Permit Number: 050792

has permission to build 22'x24' family room/bedroom add to the family residence

City of Portland, Maine - Building or Use Permit

Dept: Building **Status:** Approved with Conditions **Reviewer:** Jeanine Bourke **Approval Date:** 07/11/2005

FOUNDATION PLAN

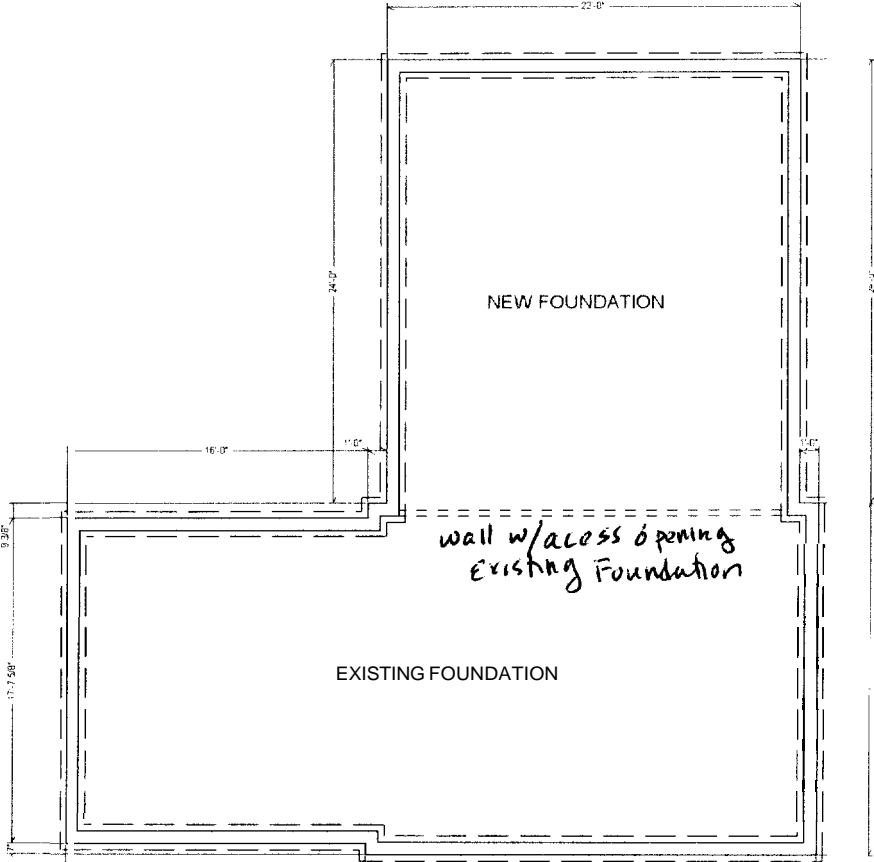
Note: 6/30/05 left vm w/owners for more info on framing details, stairs, carrying girder, insulation. **Ok to Issue:**

7/7 Bobby McT. Called to confirm details as noted on plans, he needs to submit stair details for new basement

stairs.

7/8 received stair details, ok to issue
